Your Ref: 22/02146/FUL  
Our Ref: Y013406

25th October 2022

**The Yews Stamford Bridge Road Dunnington York - Conversion of agricultural buildings to create 4 dwellings. Creation of domestic curtilages . Conversion of pole barn to parking area . Single storey rear extension to Yew Cottage . Removal of agricultural buildings**

Drainage Strategy - Scale (1:250)

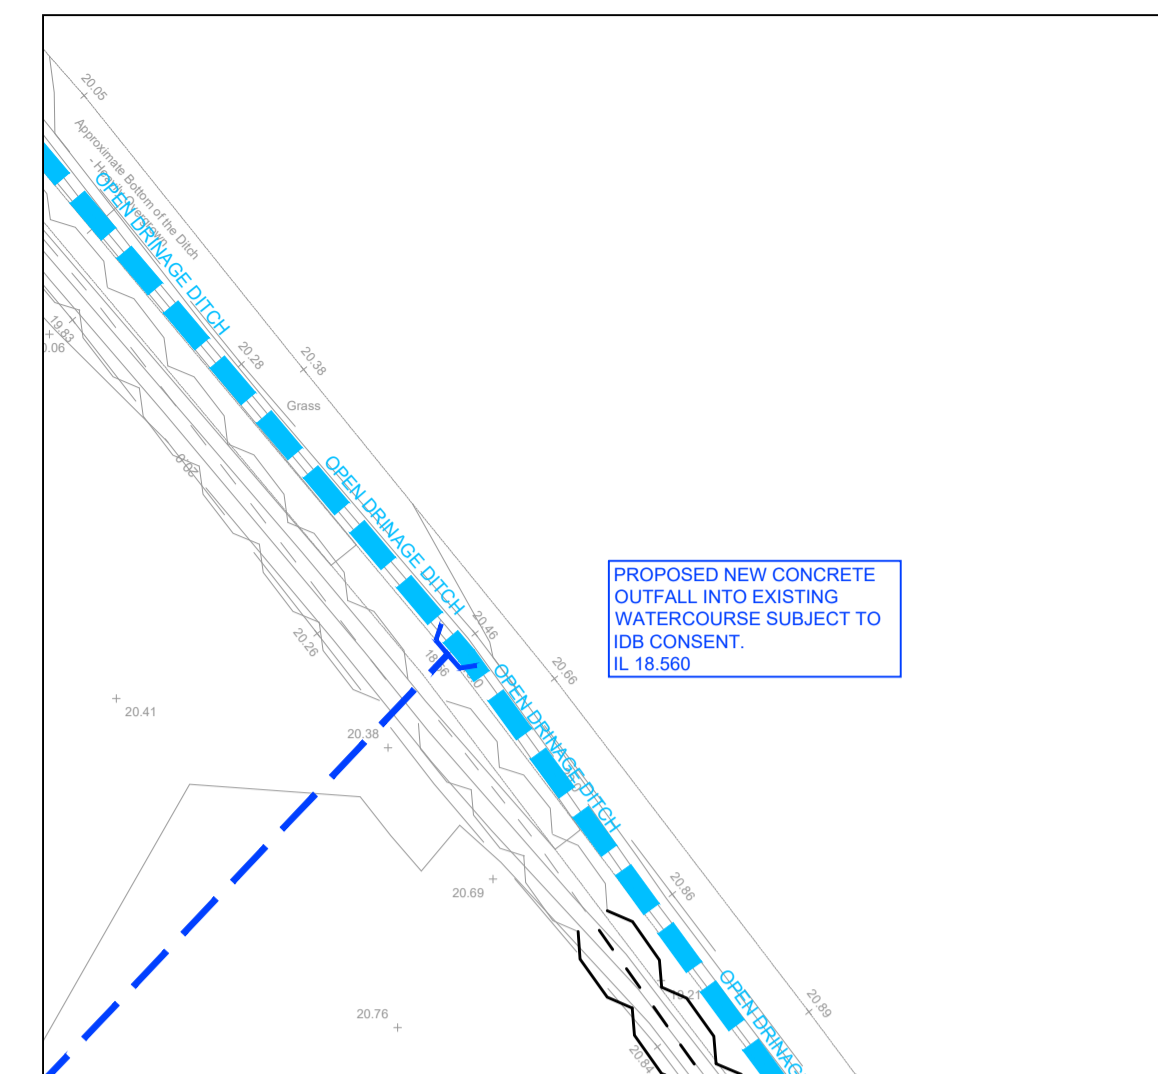
The drainage strategy layout drawing indicates treated surface water from the treatment plant and clean surface water via storage/attenuation outfalling to off-site local watercourse, subject to IDB consent.
